Recommendation Report for Planning Permission for Works or Extension to a Dwelling

REF NO: BN/22/26/HH

LOCATION: 101 Barnham Road
Eastergate
PO22 0EQ

PROPOSAL: Single storey side extension and addition of bay window to front elevation.

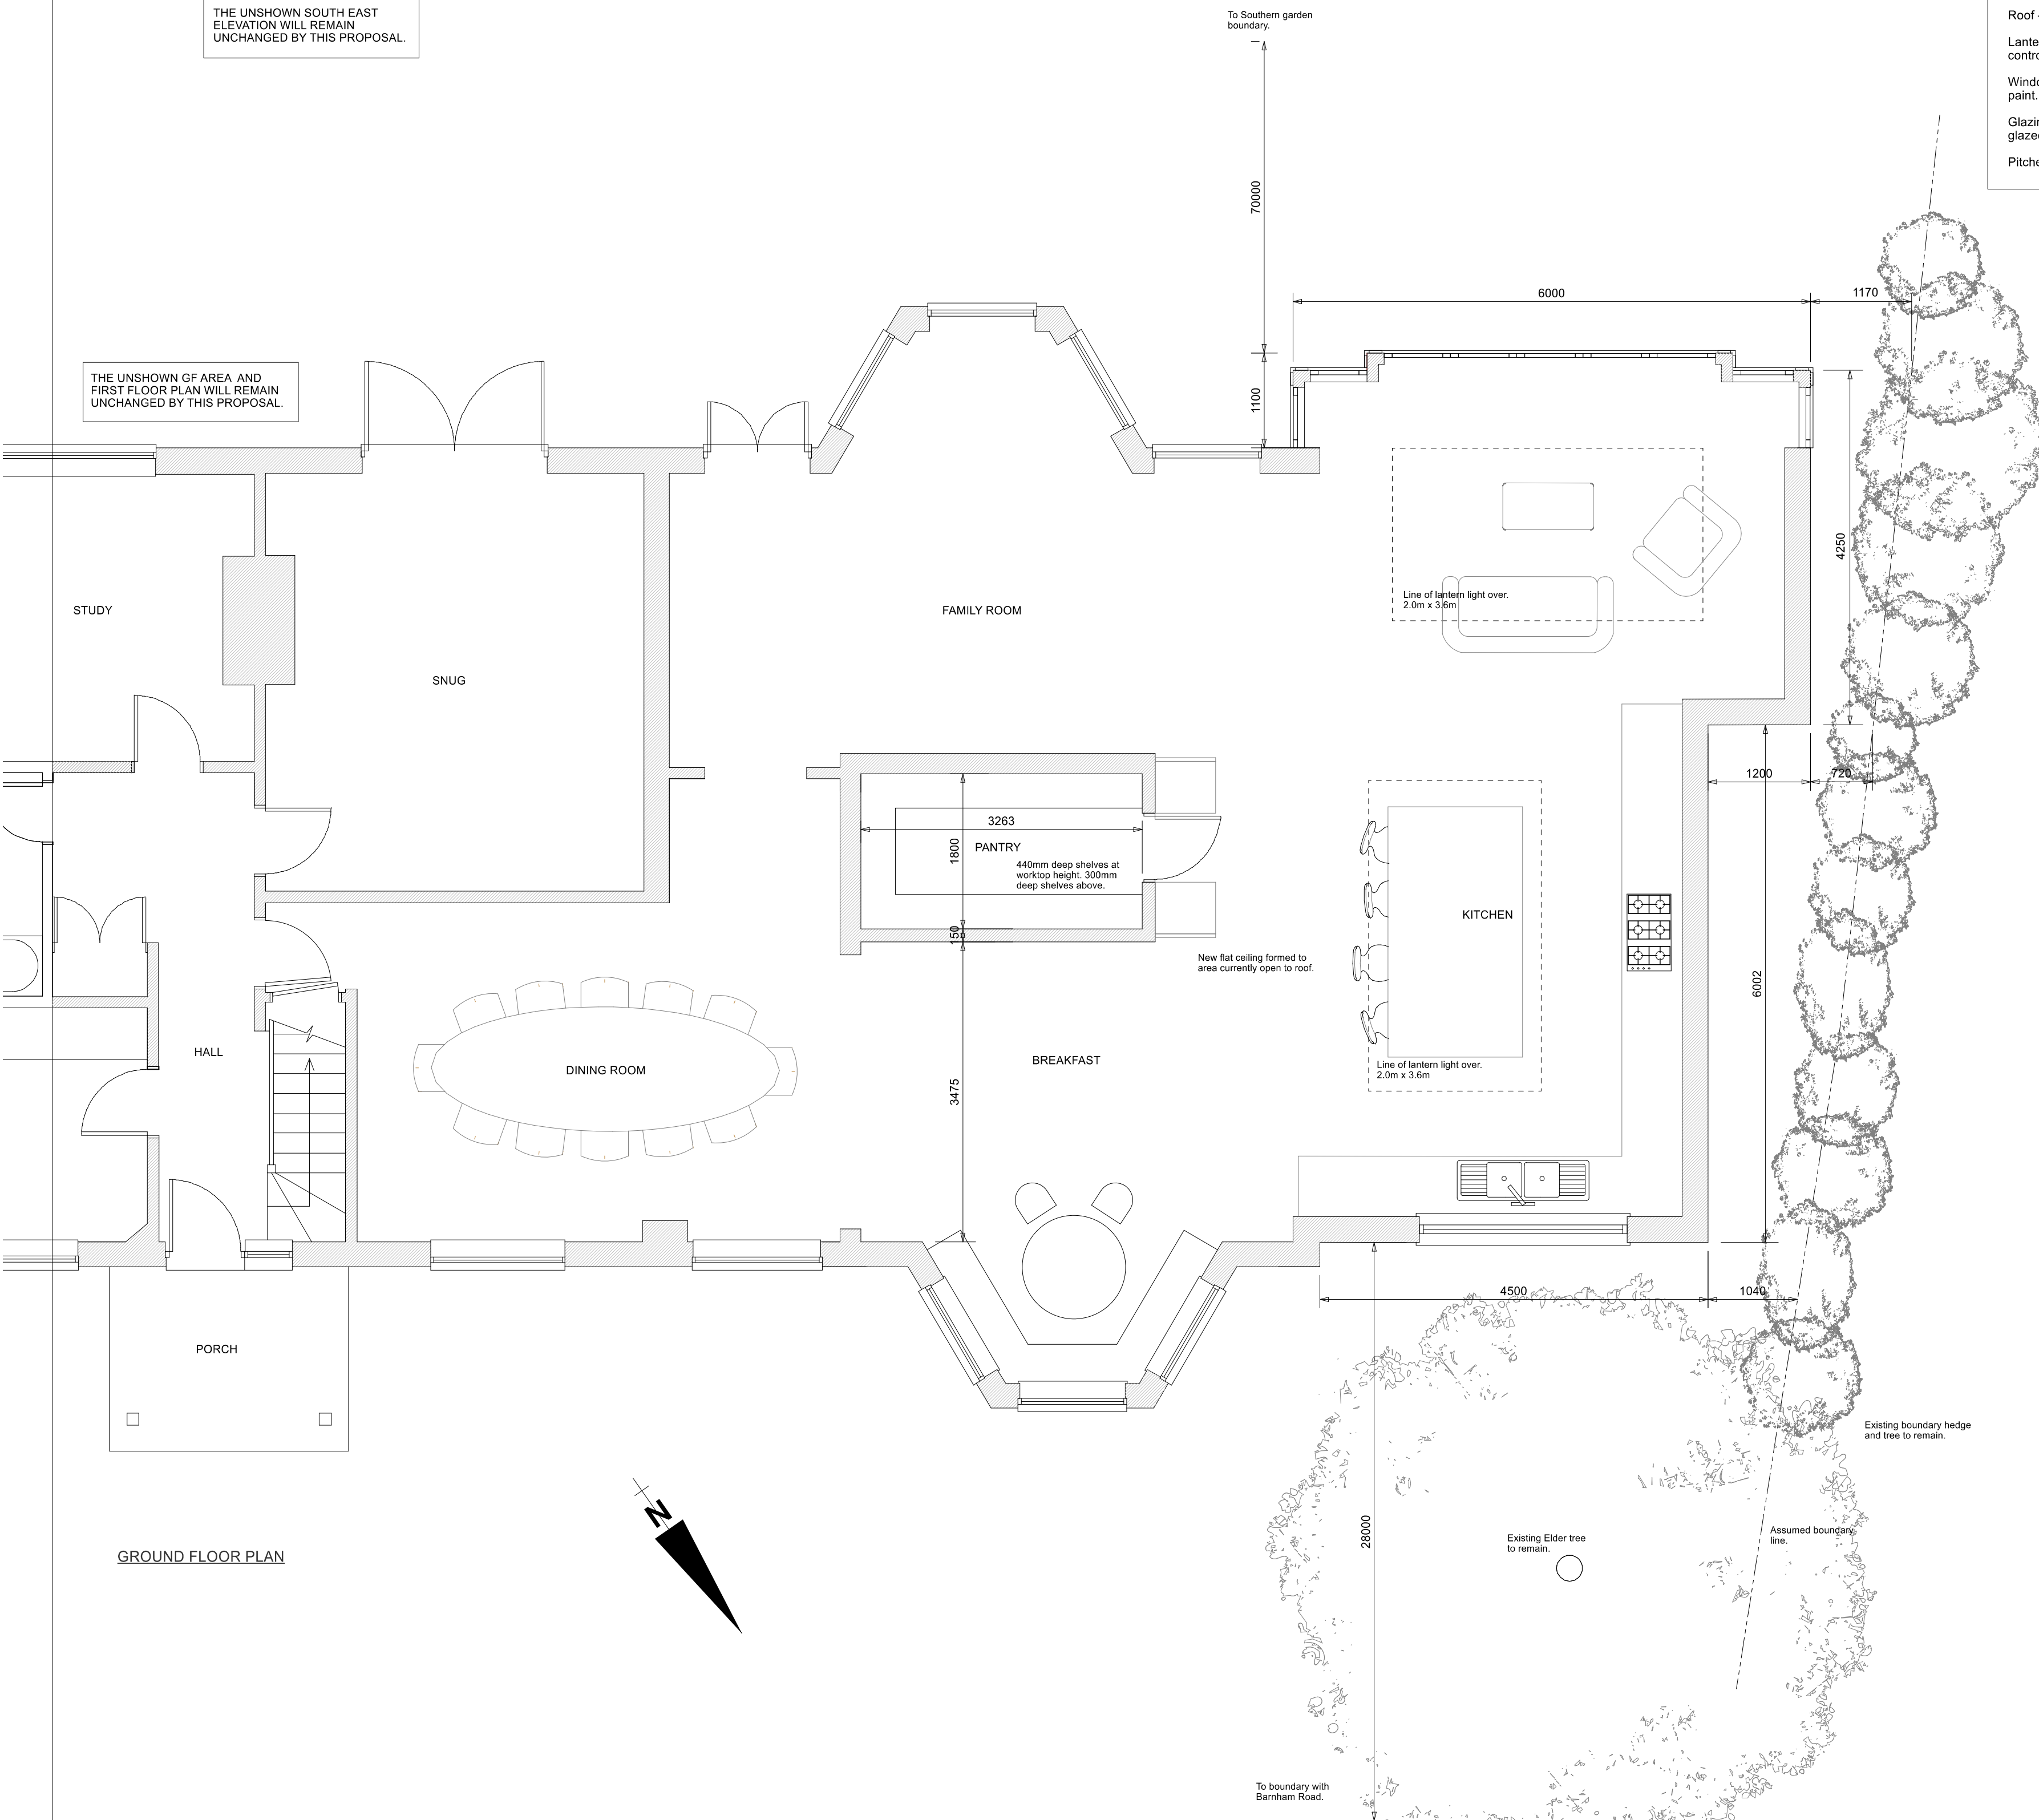
The bay window proposed at the front of the property would be a positive addition, reflecting the existing bay window at the rear in both scale and roof form. In terms of materials, the new windows and doors will have hardwood frames with double glazing, sympathetic to the character of the area. The side extension would be constructed from facing brickwork to match the existing dwelling.

The proposal is of an appropriate scale, constructed from sympathetic materials and would be significantly set back from the front boundary of the application site. Thus the proposed extension would not appear unduly prominent within the area of character. Furthermore, whilst the extension would have a flat roof form which would not reflect the prevailing hipped roof character of the host dwelling, the wider area of character is varied in terms of the architectural styles and designs of dwellings and associated extensions and alterations. Therefore, the proposal is in accordance with Arun Local Plan policy HER DM4 and the NPPF.

GROUND FLOOR PLAN

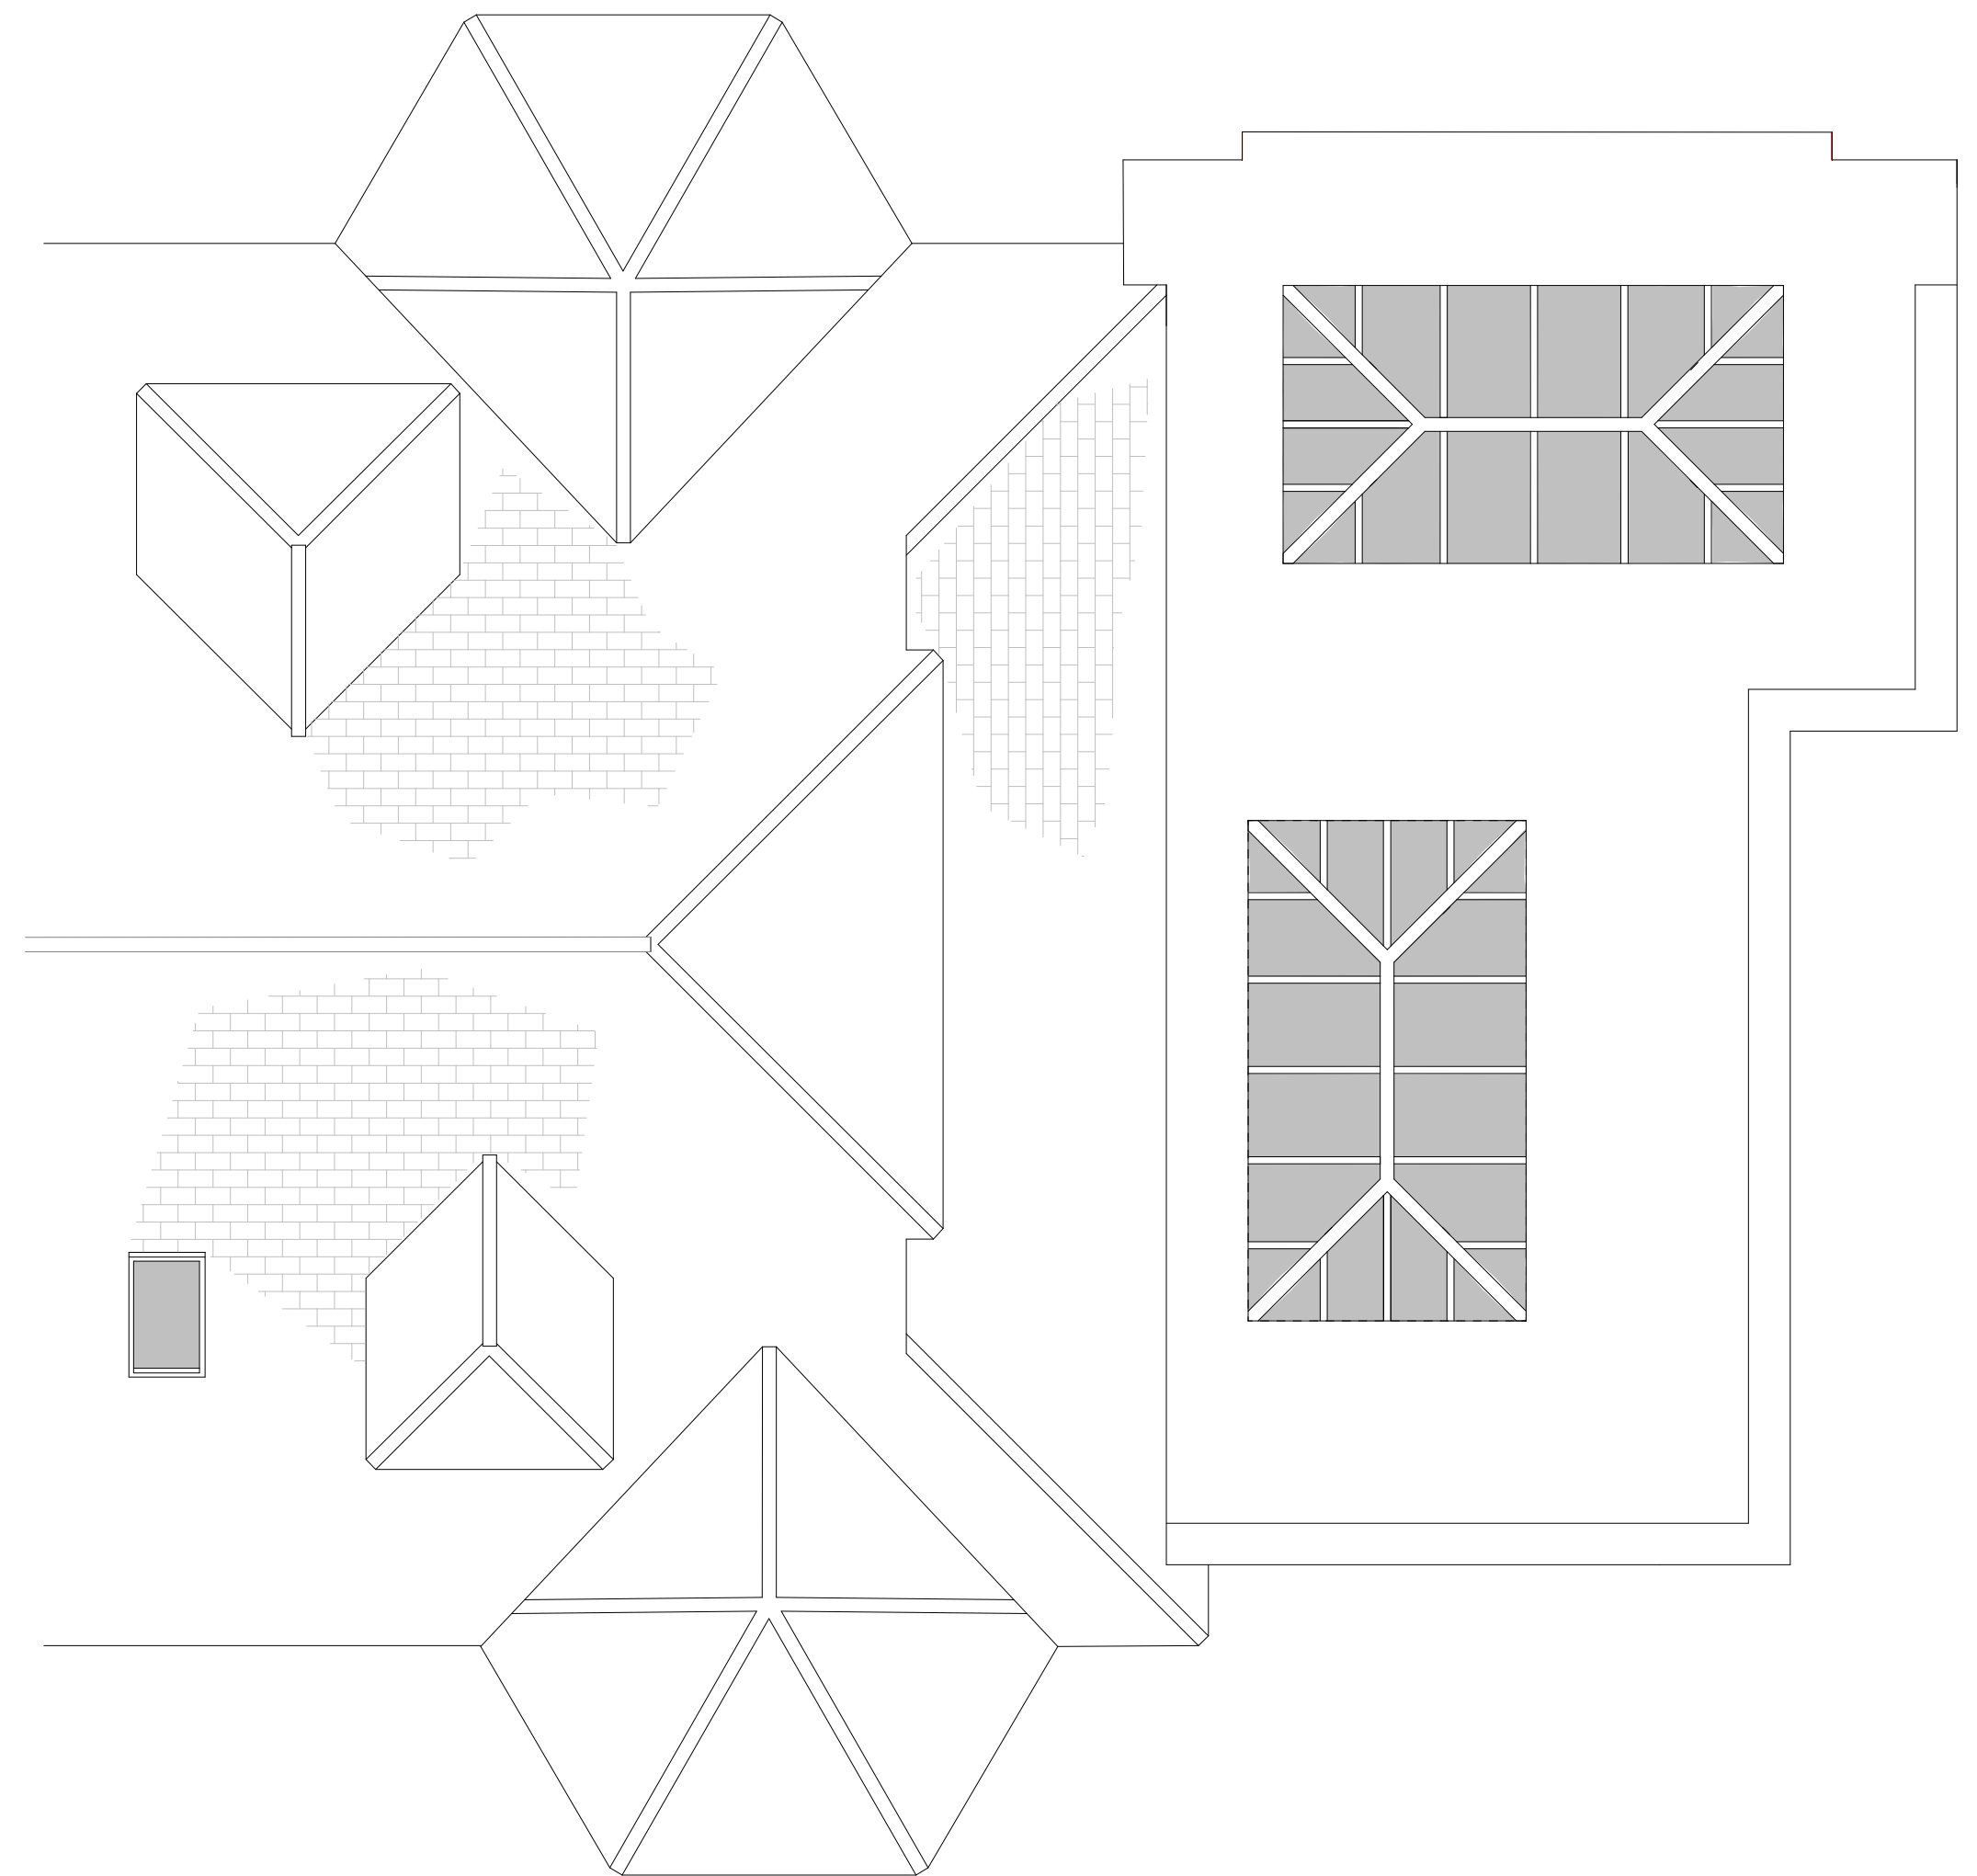
The single storey side extension would measure 4.5m in width increasing to 6m to the rear, constructed in line with the existing front elevation of the host dwelling, and a depth of 10.3m. The proposal would include two large roof lanterns set within the flat roof of the side extension. In terms of compliance with the Arun Design Guide (ADG), the extension has a frontage less than 70% of the existing host dwelling and is mostly set 1m in from the side boundary (the projection towards the rear of the property slightly exceeds this guidance due to the shape of the site). The extension would have an eaves height slightly higher than the existing dwelling, however given that the extension would be set back from the highway by approximately 29m and would be screened by mature trees, this would not result in demonstrable harm to visual amenity. It should be noted that a side extension of a similar footprint could be constructed under permitted development rights if the height of the eaves were compliant with the guidance.

At its closest point, the side extension would be set in from the north west site boundary by 0.7m. Due to the staggered side elevation, most of the extension would be set in by 1-1.5m from the boundary. The

The extension would be single storey, with no fenestration proposed within the north western flank elevation. Fenestration within the front and rear elevations would have views of the front and rear gardens serving the host dwelling, and as such, the proposed extension would not result in any harm to neighbouring amenity by of overlooking impacts.
